facsimile transmittal

To: Dennis Paul Watson **From:** Mike Nugent

Re: Morrill St. Associates 57 Bell St.150b001

I have started the review of the above project and have questions:

ANCHOR BOLT SETTING PLAN

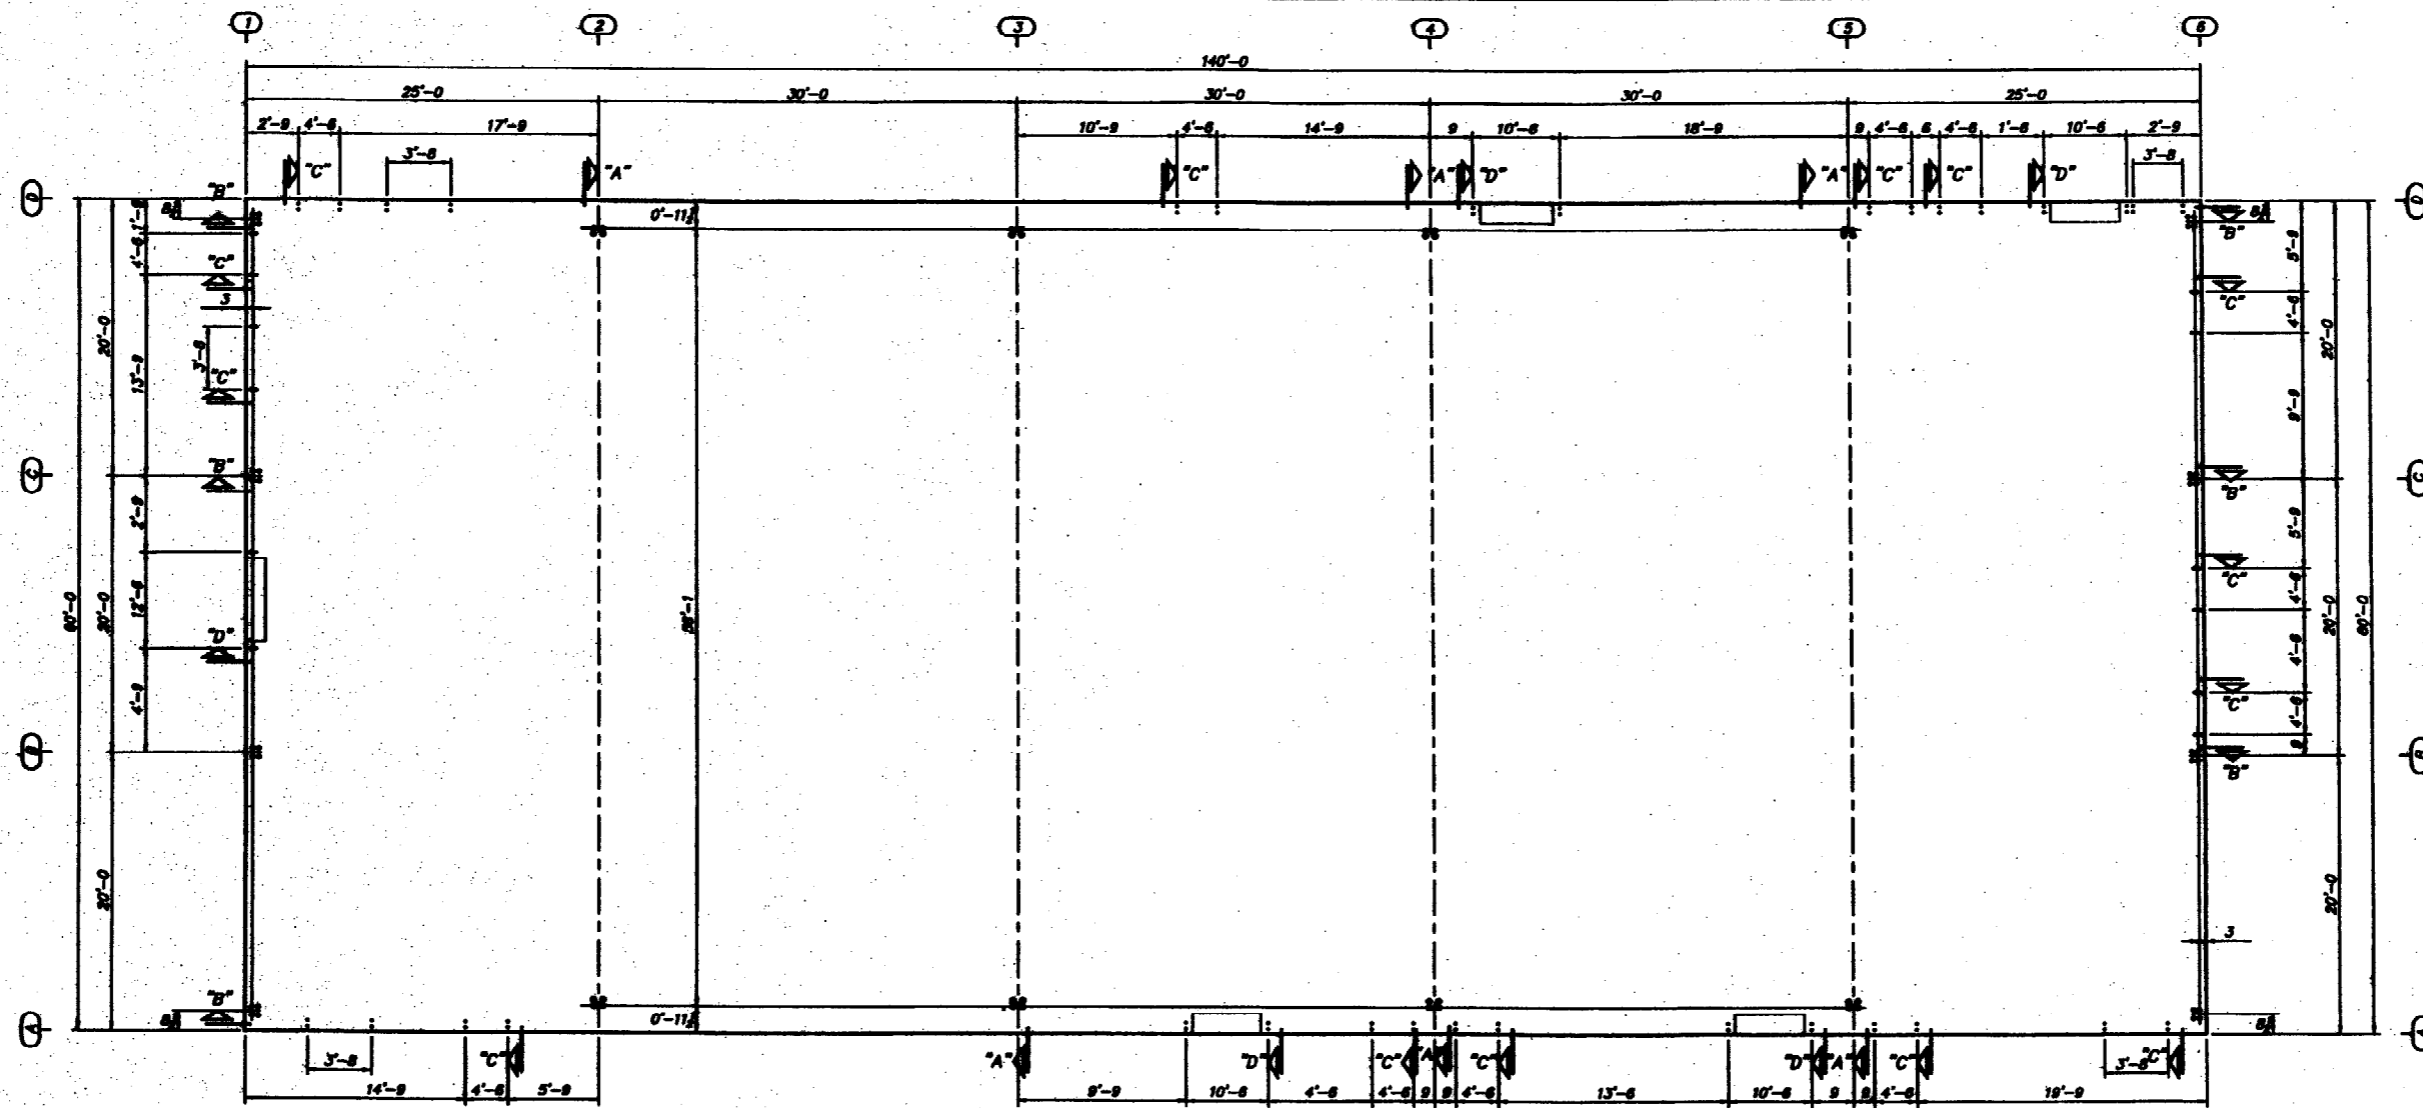
- 1) Attached are required certifications and Section 1705. of the 1999 BOCA Code which deals with Special Inspections, Please complete the forms and return them with a Statement of Special Inspection. This note applies to both the building and foundation plans.
- 2) There are hand written notes on the foundation plan, where these done by the engineer?
- 3) Your notes the "1996 BOCA Code" the City is under the 1999 BOCA Code.
- 4) Because the roof is 1:12, the roof design must be done in accordance with Section 7.3 of ASCE 7.
- 5) There is no Soils report as required by Section 1804.1 of the BOCA code.
